Application no: H16-0960-11

Description: Proposed signage

Location: 6 Francis Street
Spalding
Lincs
PE11 1AT

Amendment: Revised Signage Details (Issue 2)

SECTION A Fascia Sign (a)
Scale 1:5

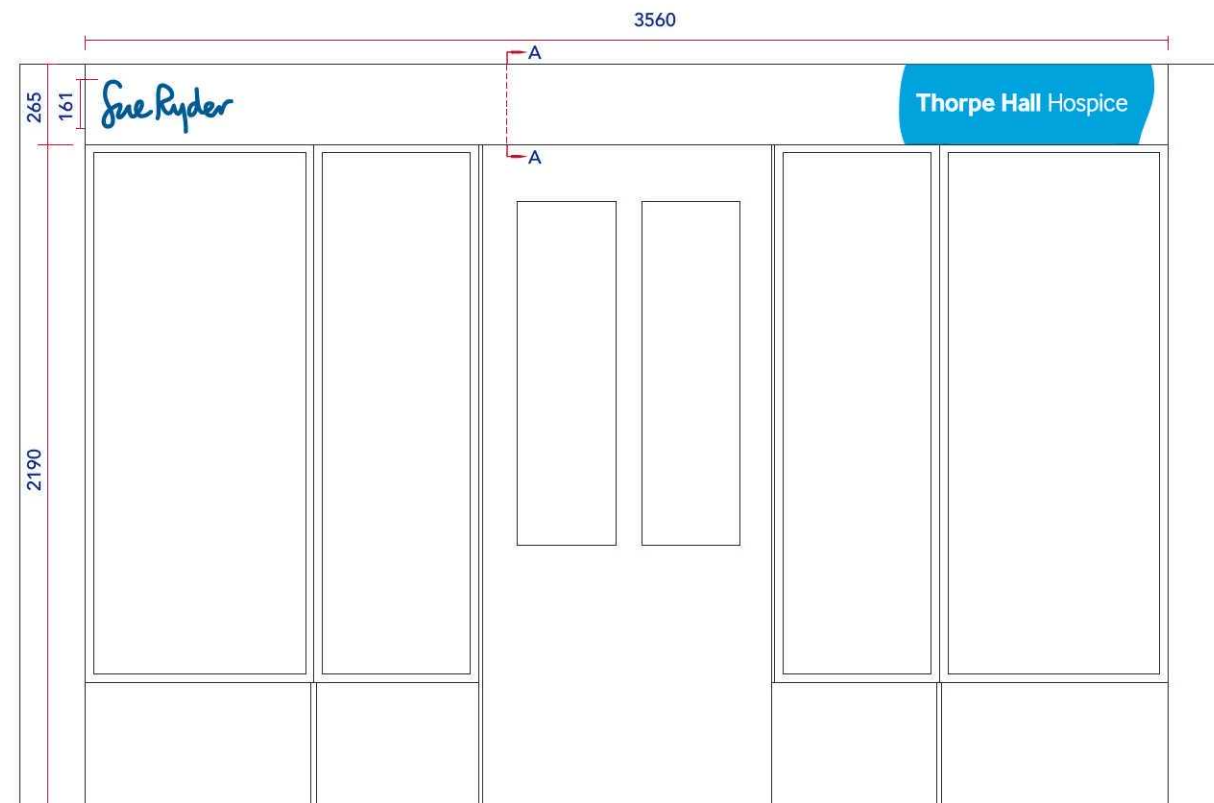
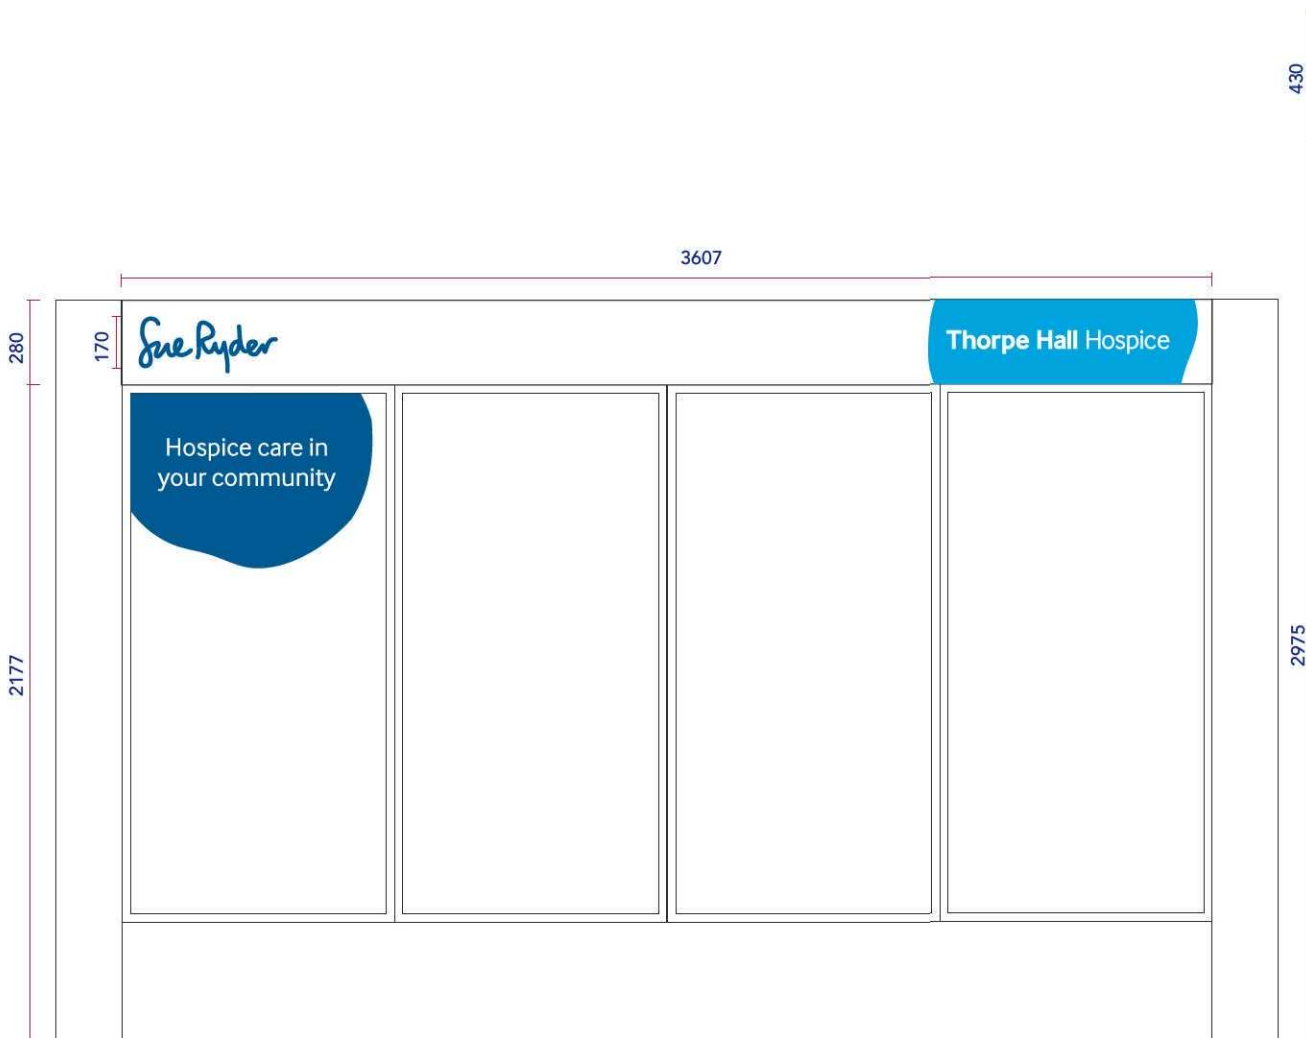
[I simply need accurate survey and proposal drawings that reflect the existing shopfront construction. This should include a vertical section through the shopfront fascia to show how the proposed signage will sit relative to the corbels/mouldings etc around it.](#)

Please find attached further details added to the cross section which I hope will clear up the positioning of the new signs for you.

The new signage will sit vertical (i.e. not sloping as per the existing panels), and will be contained within the recess between the corbels. The maximum projection will be 30mm, which is far less than the corbels themselves project.
